August 5, 2024

RE: Johnson Ag Utility Building SEPA Application (SE-24-00021)
– Transmittal of Comments (Parcel #145133)

This letter is response to the SEPA Plan Review Comments dated July 25 and the Request for Additional Information dated July 31 for the above referenced project.

Critical Areas Map

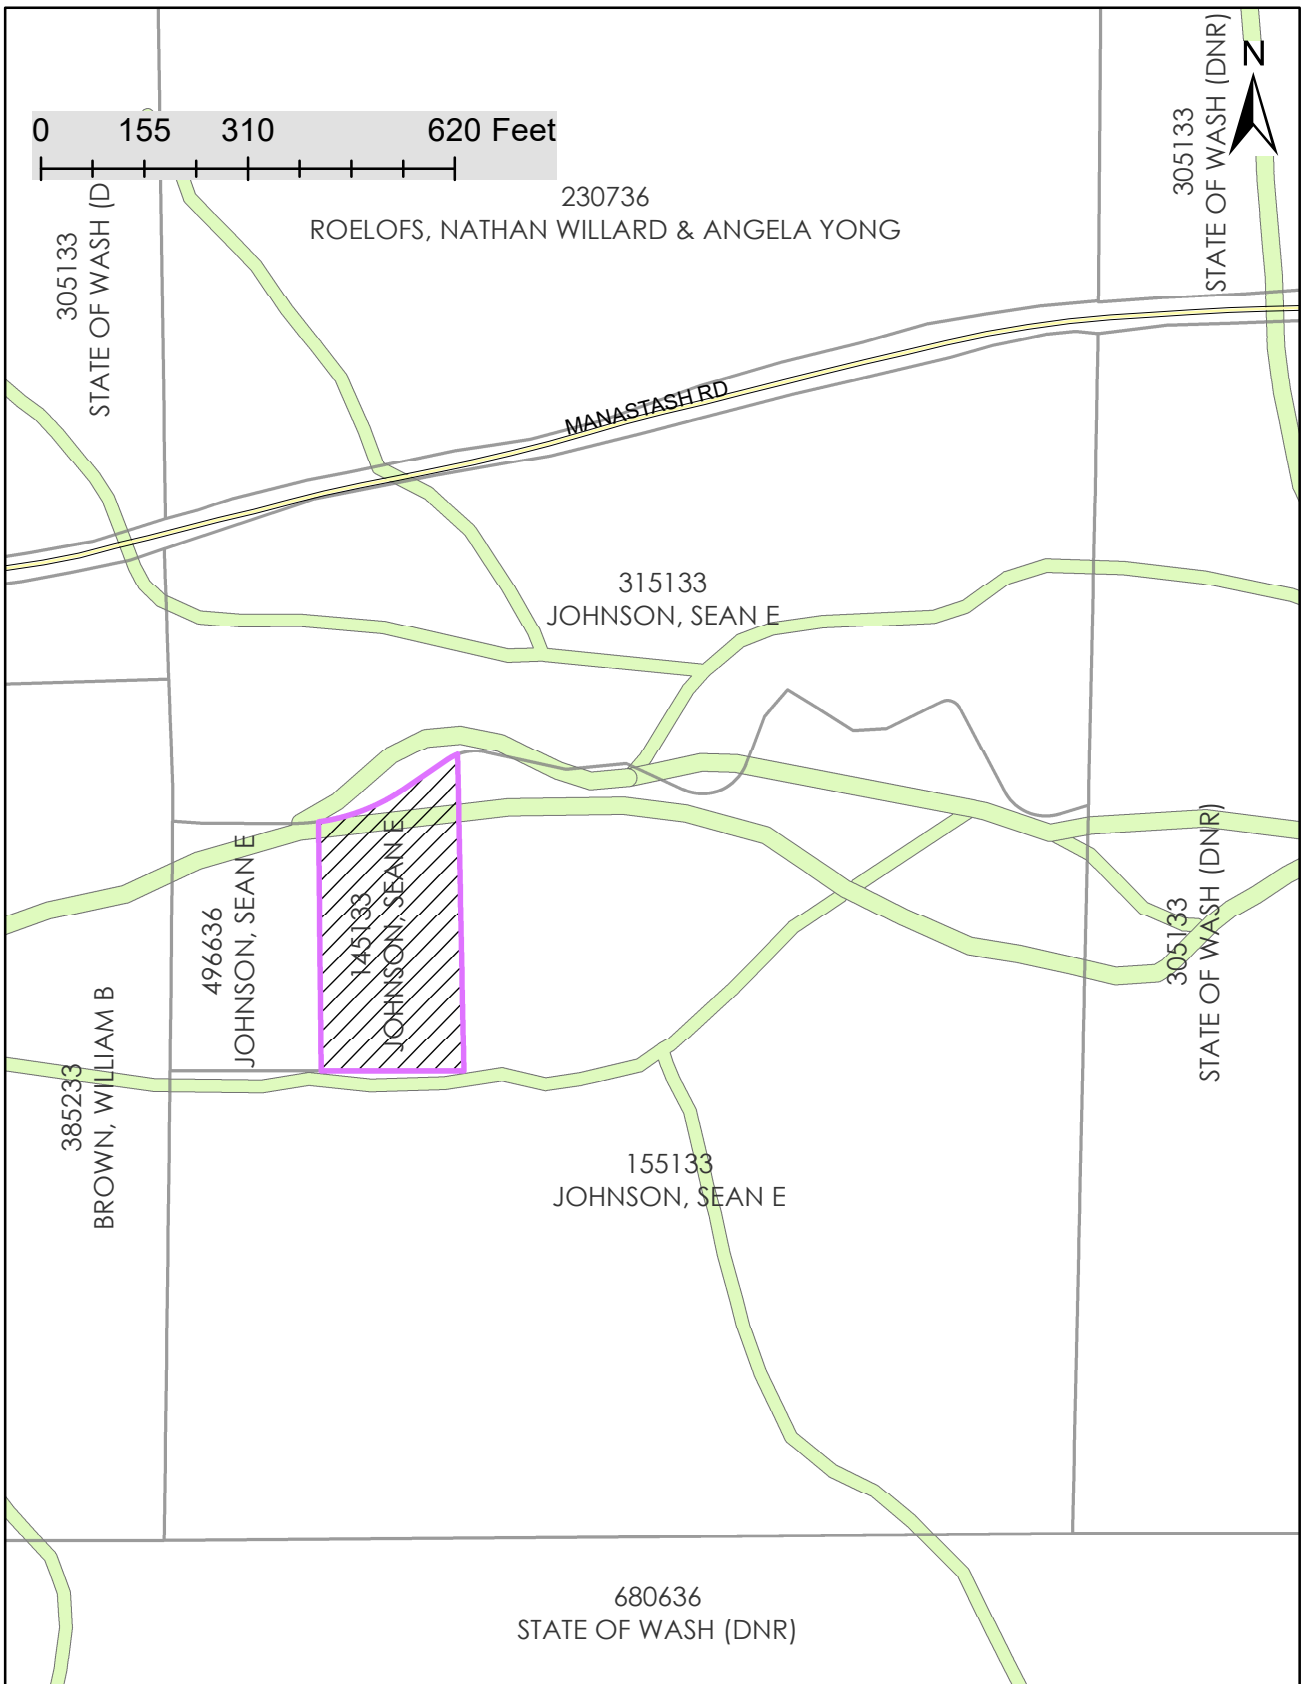
The property is located in the Rural Conservancy shoreline designation which has a buffer of 100' to the Creek. We also have concern that the site plan does not show the existing access to the construction site, nor other required information do determine if work in the buffer will be necessary to modify the existing access for construction of the new structure. If so, this work may trigger the need for additional shoreline review.

WDFW appreciates the efforts that have already occurred to identify the Geologically Hazardous Areas (GHA) such as the Channel Migration Zone and steep slopes. We did not see information provided about frequently flooded areas or other critical areas such as Critical Aquifer Recharge Areas, Wetlands, or Fish and Wildlife Habitat Conservation Areas (FWHCA). We would welcome the opportunity to have a site visit with the applicants and/or County to better understand the potential risks or benefits to all critical areas, particularly the FWHCAs.

BORA – The new structure is an Out / Utility Building separate from the existing single family residence. No dwelling units will be part of the new structure. The parcel is a single family residence, there are no commercial working farmlands. The structure is roughly 314' to Manastash Creek. A Channel Migration Zone analysis had been conducted and submitted showing it is unlikely that within a 140 year time frame the creek will migrate to be close to the structure, but a Shoreline Exemption Permit was applied for under suggestion of Kittitas County personnel as the project is within 200 feet of the associated floodway, though the structure will not be within the Flood Way or Flood Plain.
